SCOPING OPINION:

Proposed Chesterfield to Willington

Case Reference: EN0210001

11 December 2024

Figure 9.1 to Figure 9.2

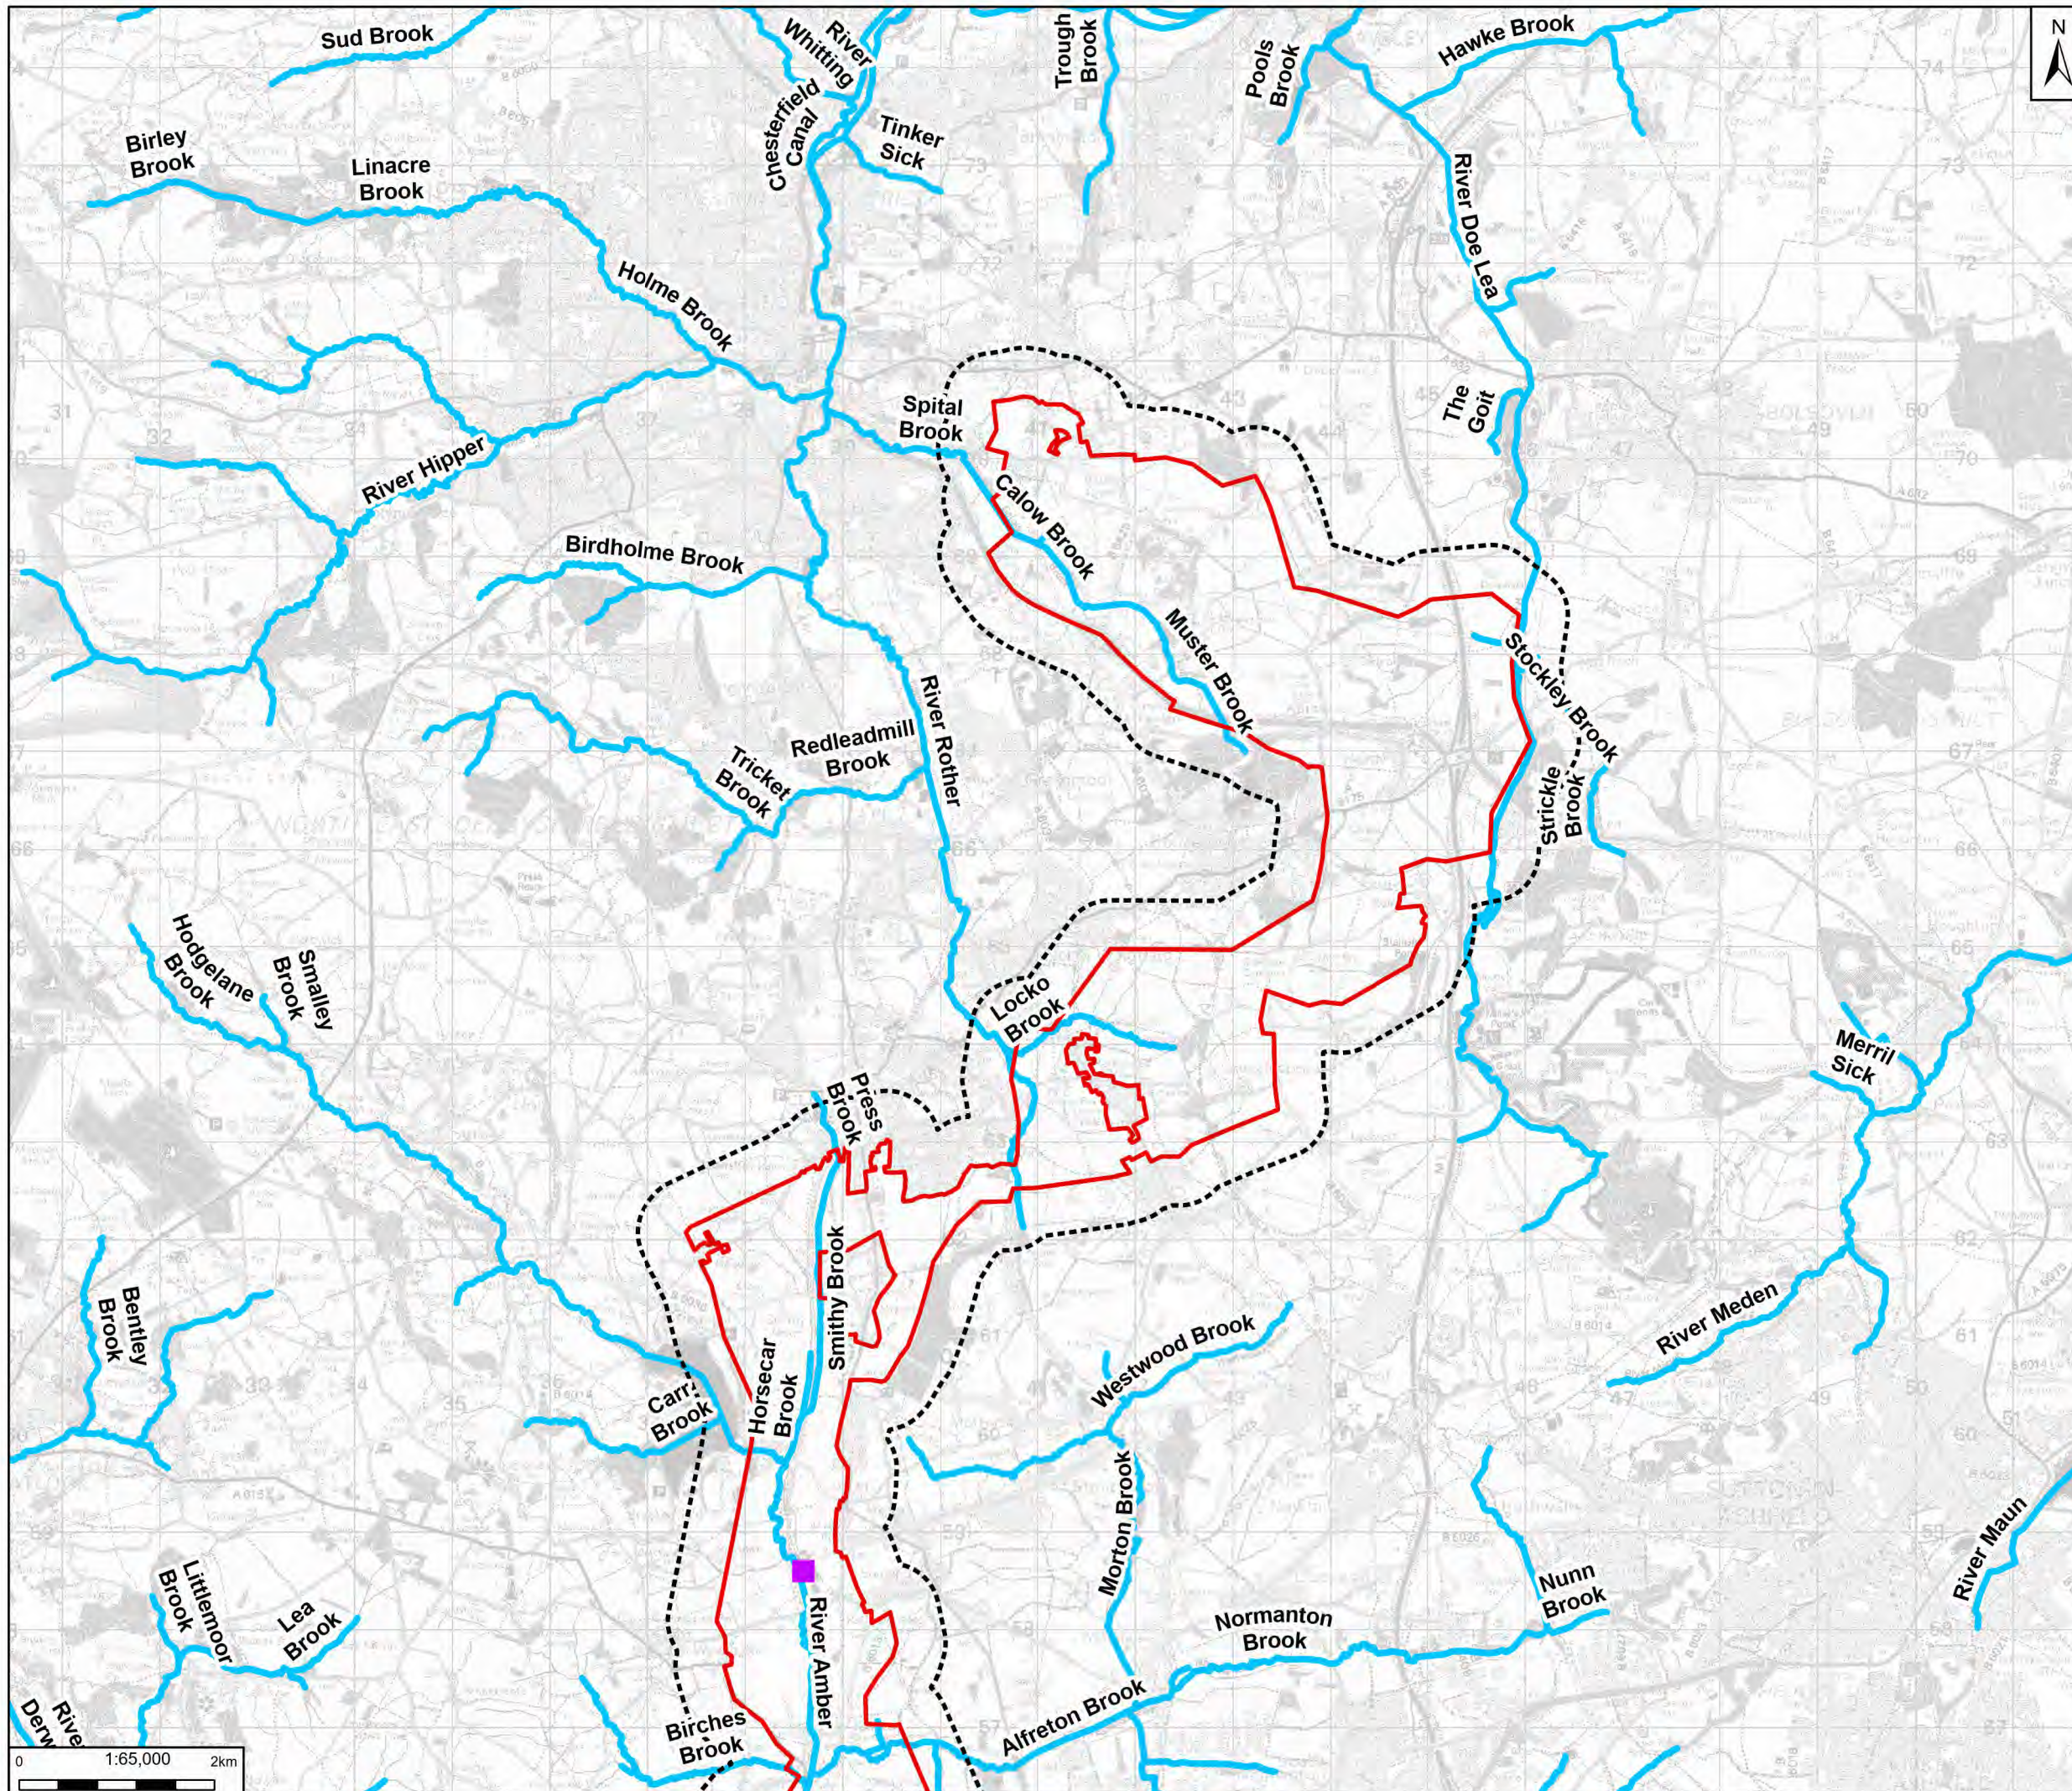
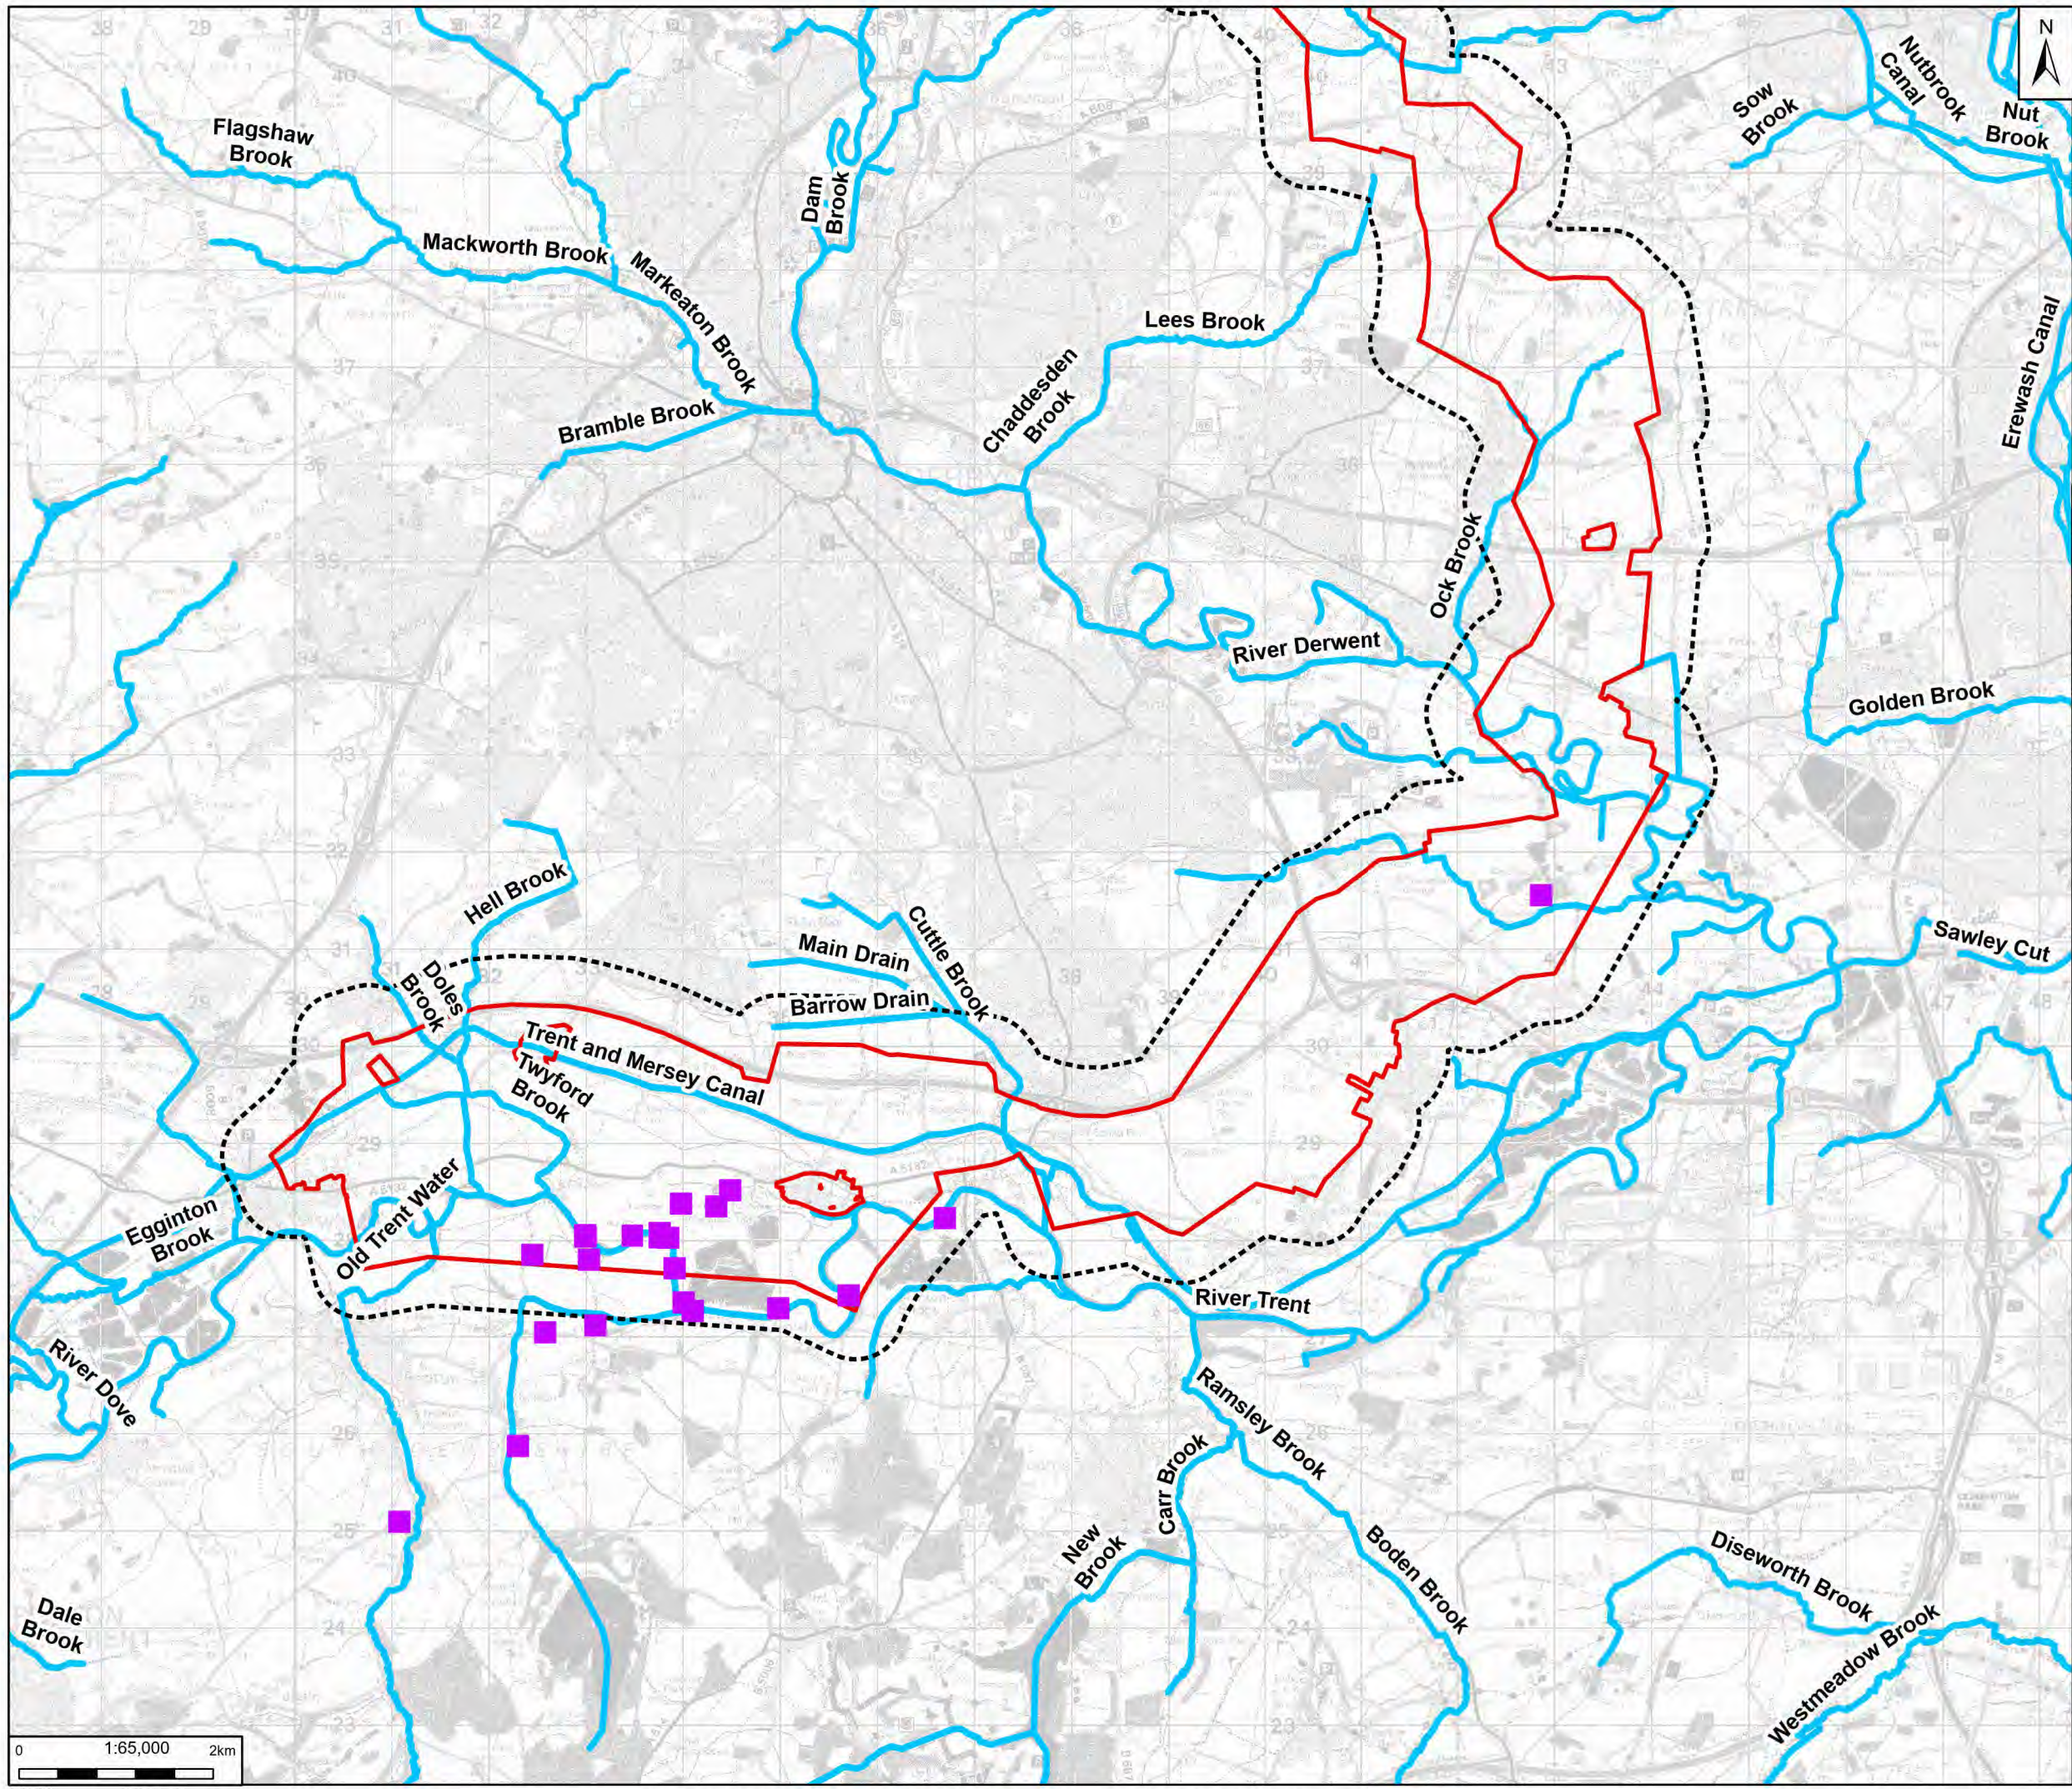
3.1.10	n/a	Recreational receptors	The Proposed Development could cross the Trent and Mersey Canal (Figure 9.1) and other canals are in proximity, including Cromford Canal and Nottingham Canal. Consideration should be given to the potential for likely significant effects from the visual impact of cables from the canal network, including at crossing locations and where the landscape does not provide for easy visual mitigation of the works. Consideration should be given to the impacts of lighting near to the canal and waterway, including the potential for distracting boaters at dusk. The ES should identify any specific mitigation which may be required.
